October 15, 2025

**Re: Paradise RV Park (aka Birdie RV Park) Phase 2 at 221 Leonidas Ln NW
Erosion and Sediment Control Plan – K08E003 – (SWQ-2025-00046)
Engineer's Stamp Date: 10/2/2025**

James D. Hughes, P.E., CPESC
Principal Engineer, Planning Dept.
Development and Review Services

[Signature]

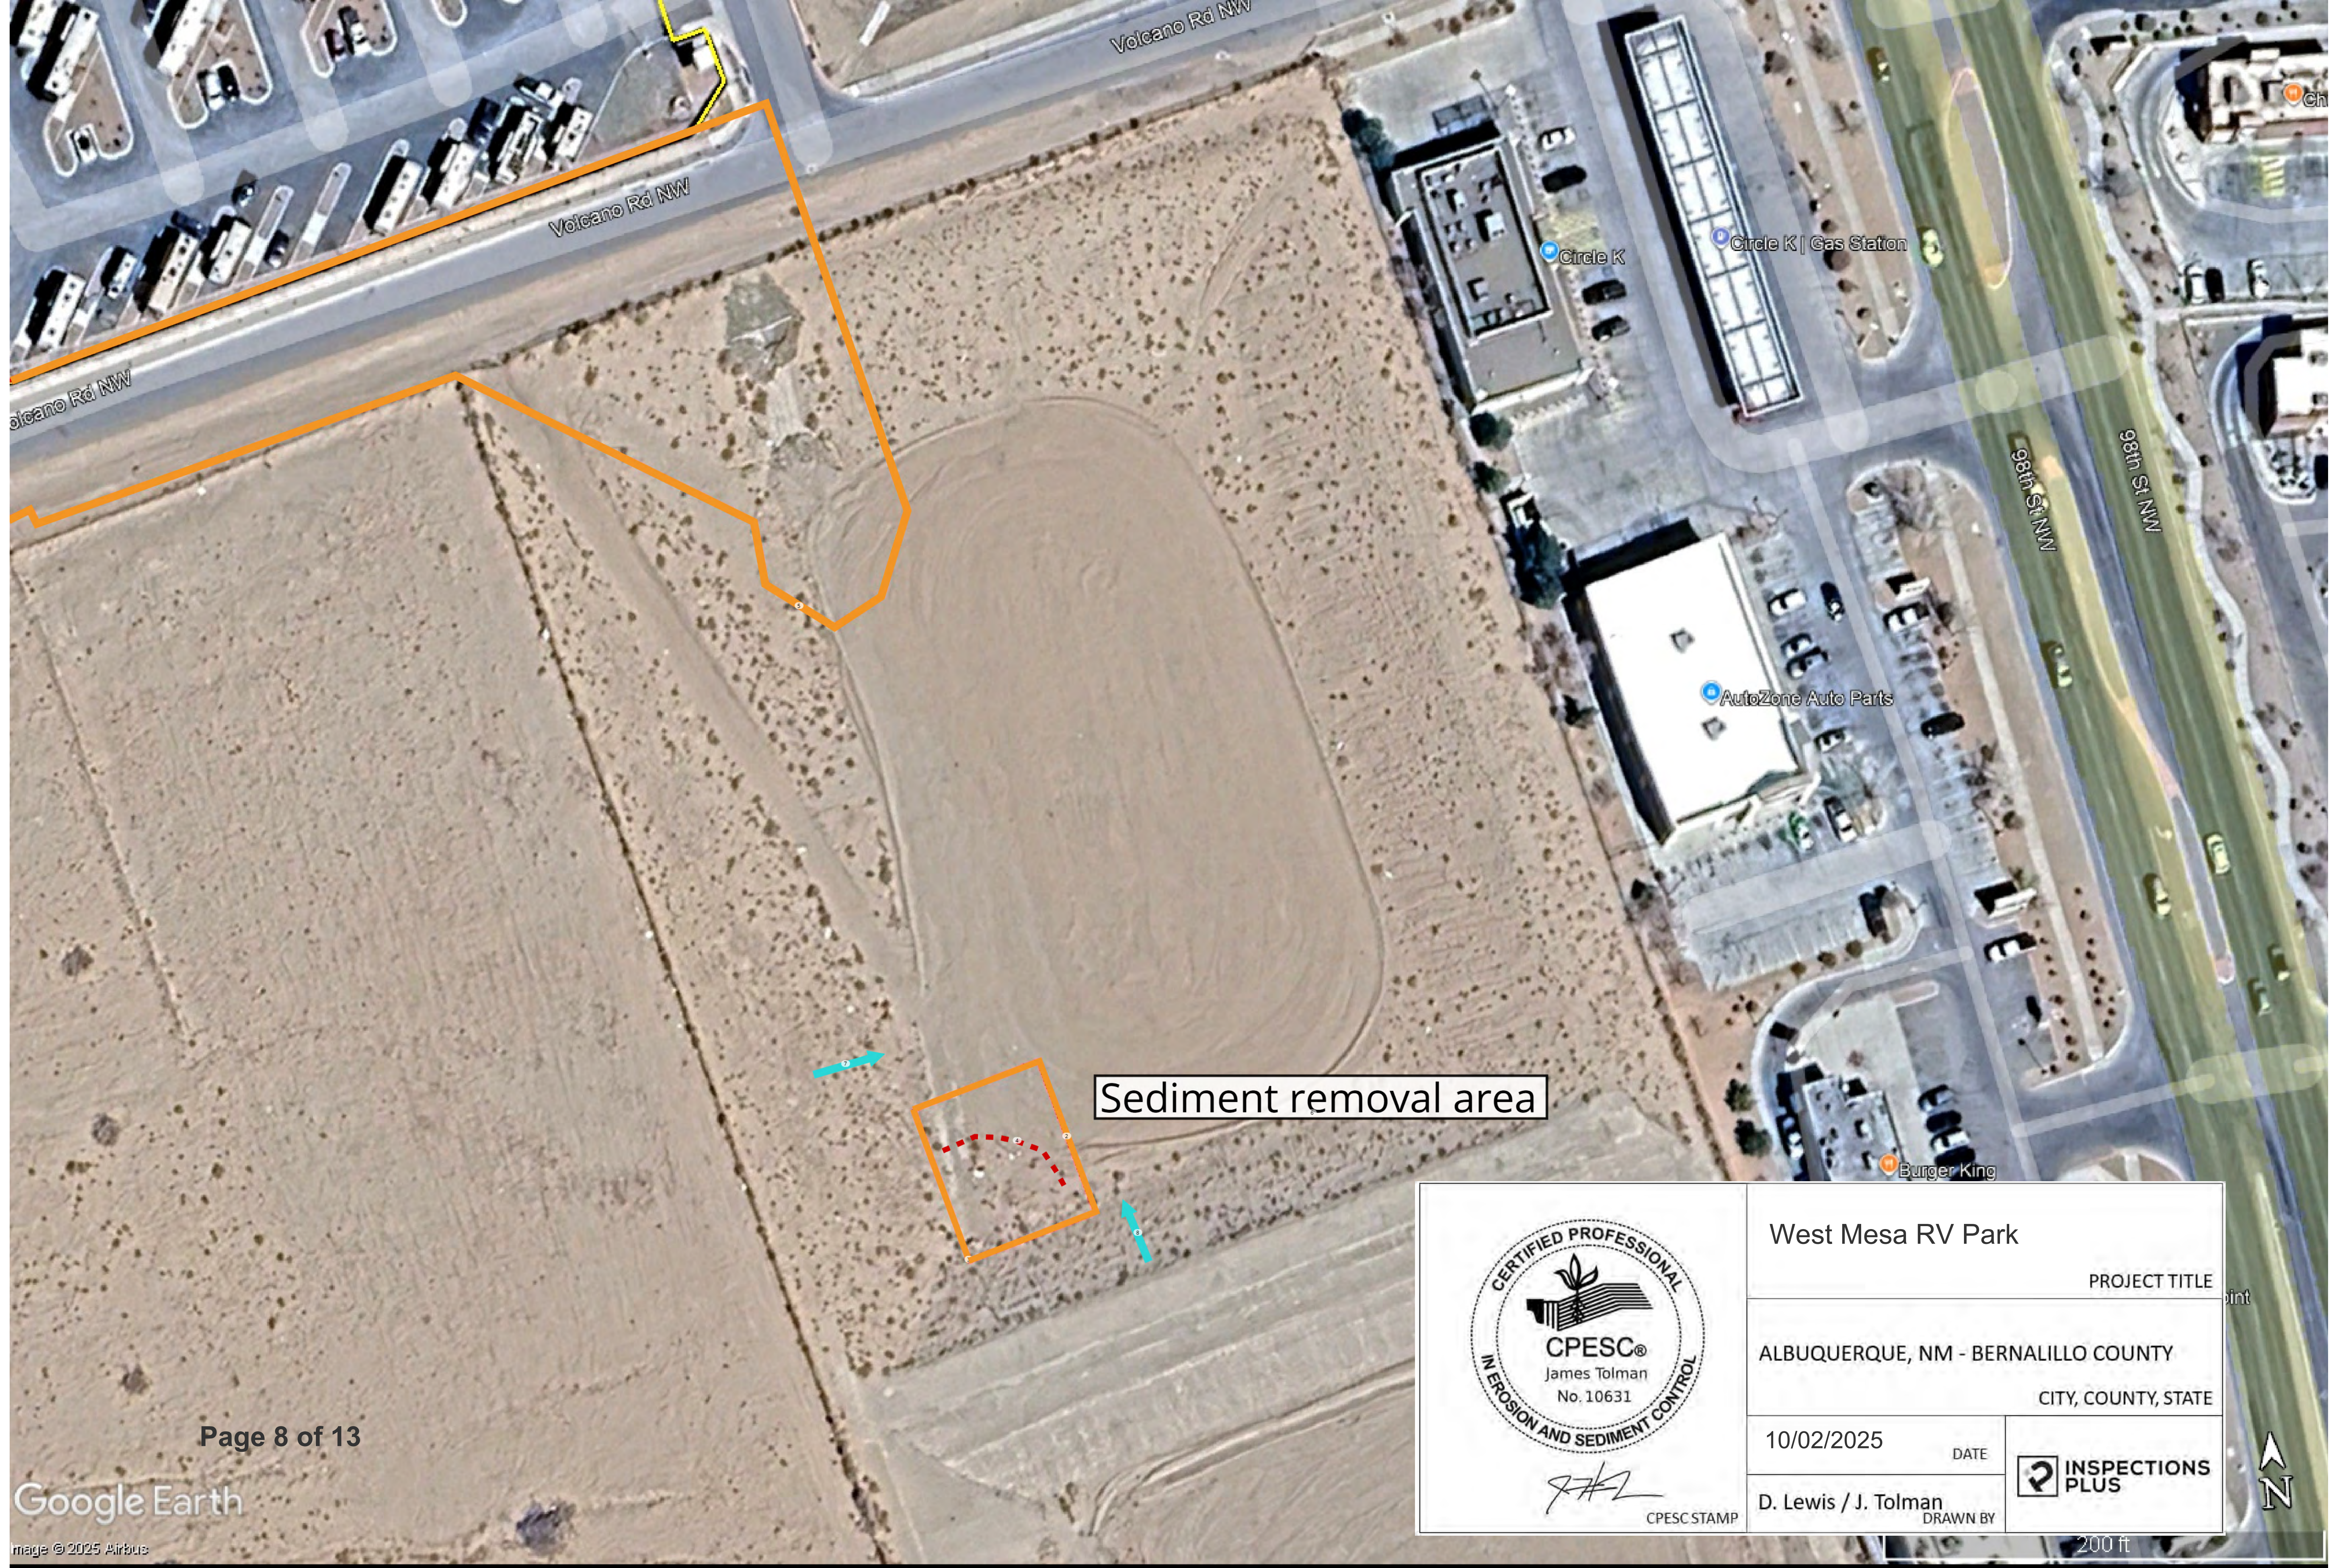
1. The construction support activities west of 102nd St. are not shown on the ESC Plan. Include the limits of disturbance around the 3000 CY hole west of 102nd on the ESC Plan as construction support activities directly associated with this site. Clarify the final plan for the disturbed area, including the schedule and details for final stabilization. Will the hole be filled or left open after construction is completed? Since approximately 3000 CY of grading west of 102nd St. is in Bernalillo County's jurisdiction, provide documentation showing that it is acceptable to them. Also, submit the off-site pond design to City Hydrology if the pond west of 102nd St. affects the existing, interim, or final drainage plan.

2. The extent of repairs needed to fix damages to the city pond has been greatly underreported and misrepresented on the ESC Plan. Phase 2 construction started over a year ago without BMPs. It diverted off-site flows into the pond, which caused severe erosion of the pond maintenance road and significant sediment buildup at the pond bottom. Clearly define the construction limits inside Pond NE2 on a Remediation Plan to be included in the G&D, WO, and ESC Plans. The remediation Plan must include: areas damaged by erosion on the access ramp, sediment accumulation at the pond's bottom, restoration of the damaged low-flow channel between the inlet and outlet at the pond's bottom, and reconstruction of the fence and gate that fell into the erosion hole. Details and specifications for public infrastructure repairs and stabilization should be shown on a Remediation Plan submitted to hydrology, then incorporated into the Work Order (WO) Plans to manage materials, testing, and inspections. Any additional damage to the pond during work order construction is expected to be repaired and should be documented on the Remediation Plan.
